Our Ref: EP/137/17/HH
Your Ref:

Town & Country Planning Act 1990 (as amended)
Town & country Planning (Development Management Procedure) (England) Order 2015
Application for Planning Permission for Works or Extension to a Dwelling

Development Demolition of rear conservatory & erection of single storey rear extension.
Location 3 Normandy Drive East Preston

title	Proposed Block Plan
-------	---------------------

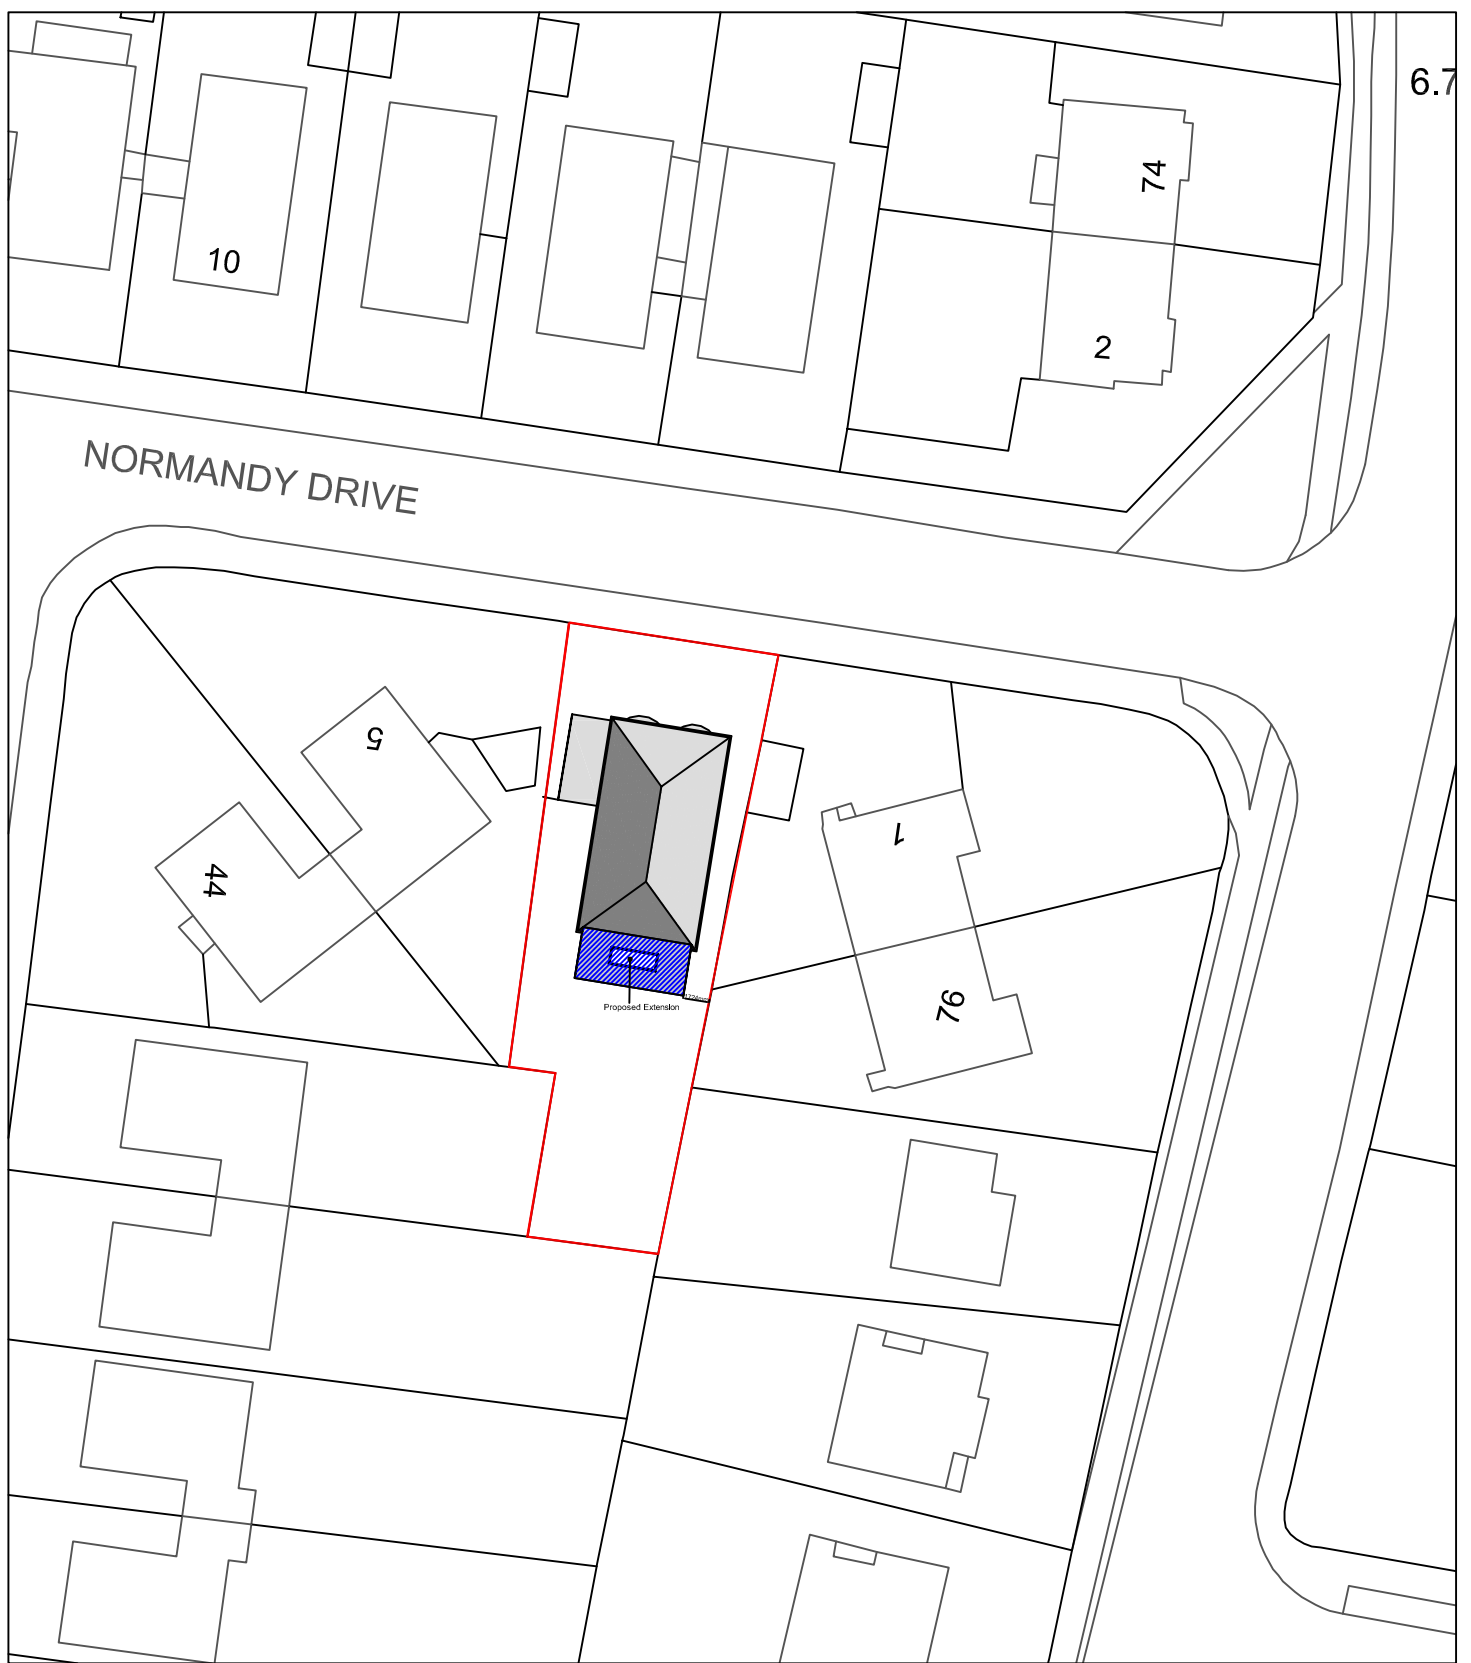
Block Plan Amend

Please submit 1 electronic or 3 paper copies of a block/site plan at a scale of 1:500 or 1:200. Further details of what must be included on the plan can be found in the National Validation Requirements. Please clearly highlight/hatch the proposed works and provide measurements from the proposal to the site boundaries.
